PLANNING CONSULTATION RESPONSE

Application No	2025/1080
Proposal	Change of use of Working Men's Club (Use Class Sui Generis) to 9x supported living dwellinghouses for adults with staff facilities (Use Class C2) including associated alterations to the exterior of the building.
Address	2 Broad Street, Hoyland, Barnsley, S74 9DY
Date of Consultation Reply	26/02/2026
Consultee	Katie Lawrence, Planning Ecologist

Drawing Title
Existing & Proposed First Floor Layouts

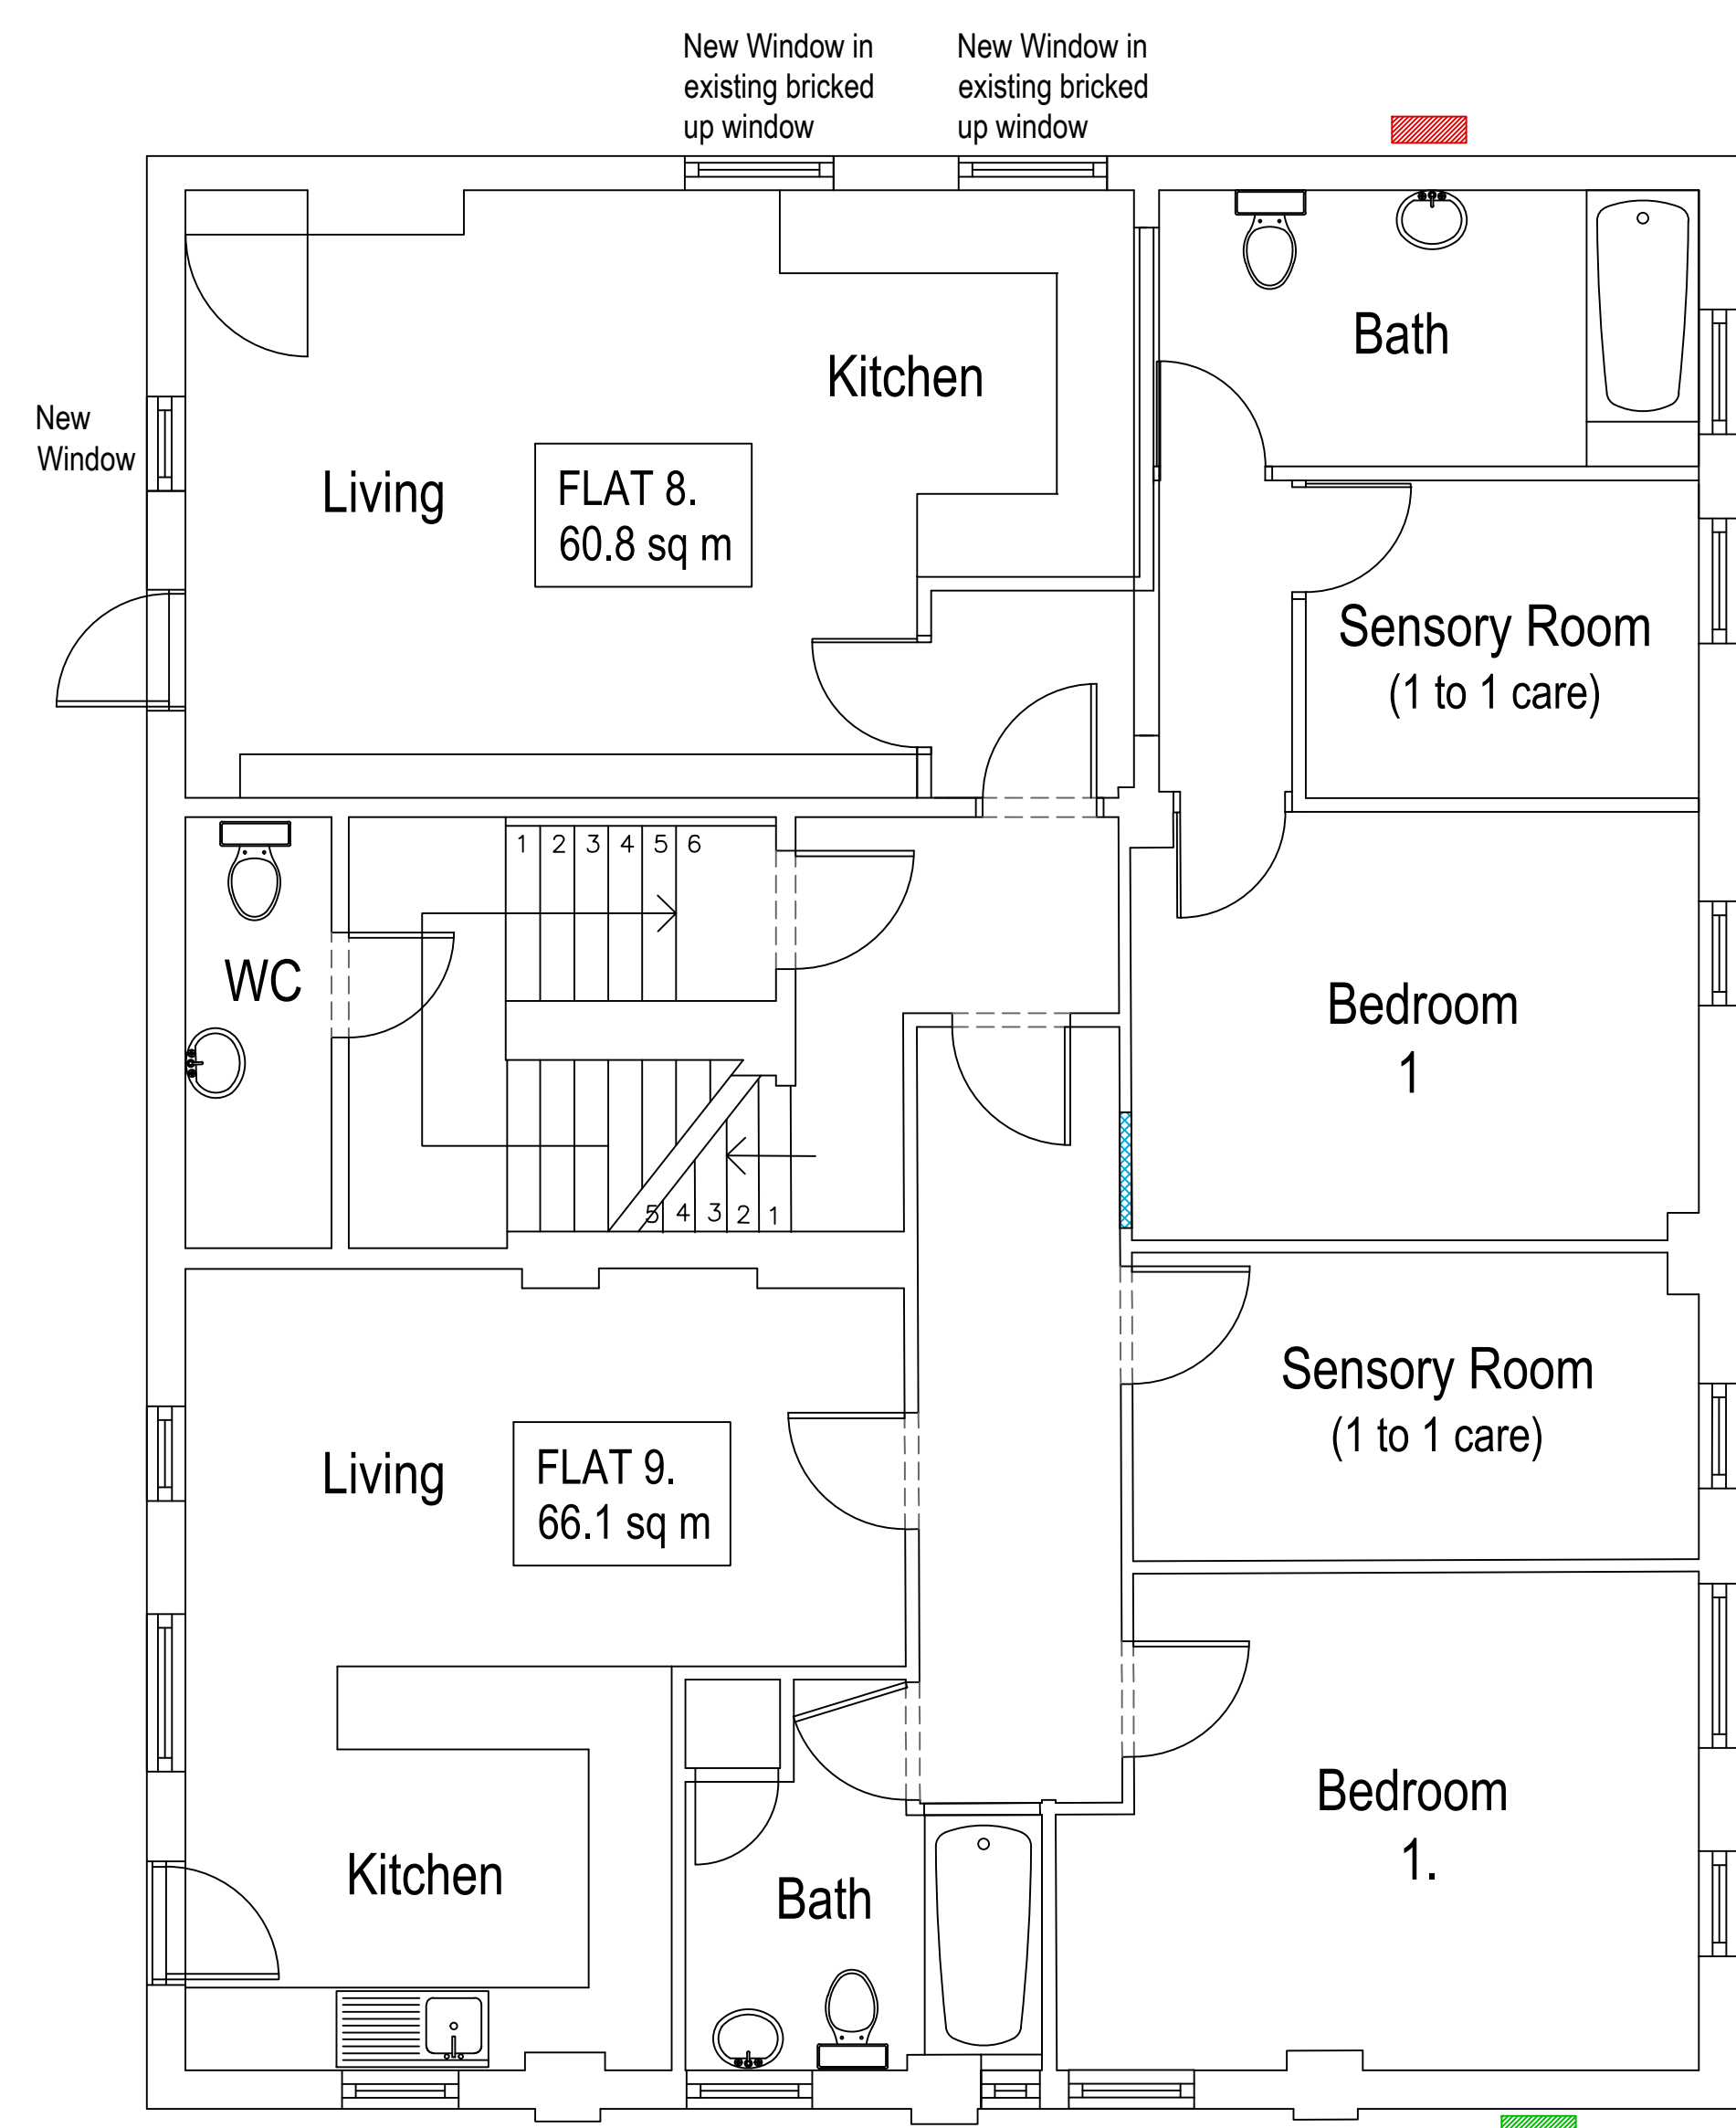
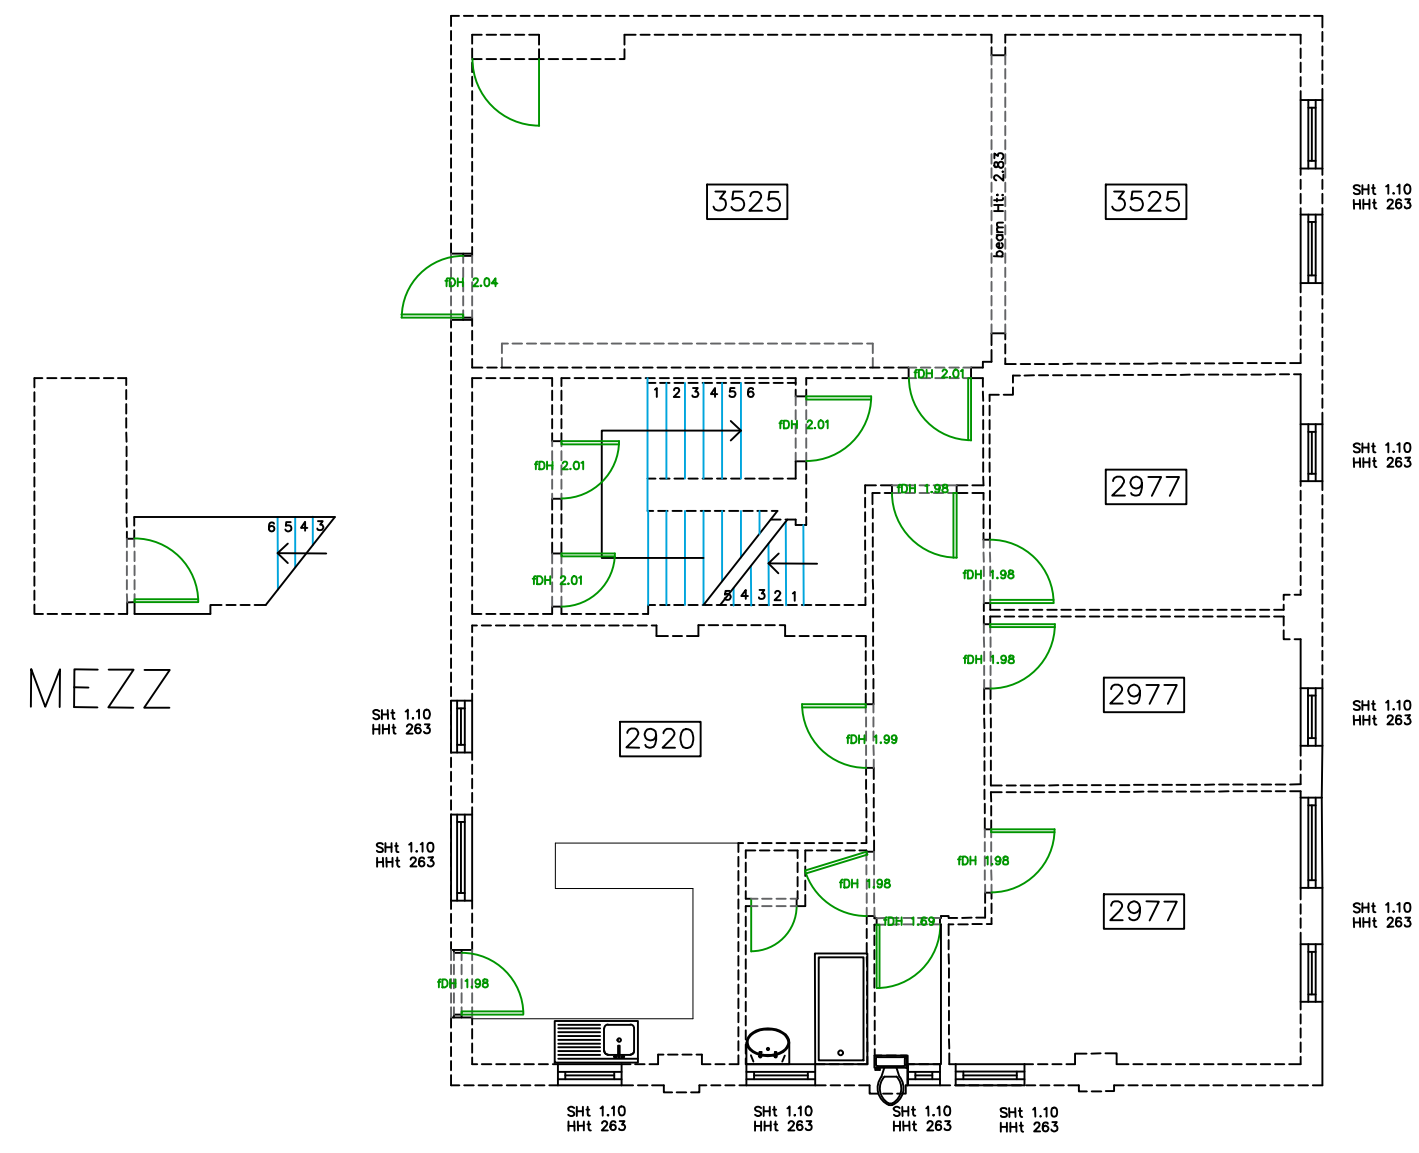
Thank you for sending through plans which show locations of bat and bird boxes on the building. As per my previous response, can the applicant provide a plan showing the types of boxes proposed, i.e. model types? In addition to that, bird boxes would ideally be located on northern and eastern elevations and bat boxes should be located to southern and western elevations and the plan should be amended accordingly.
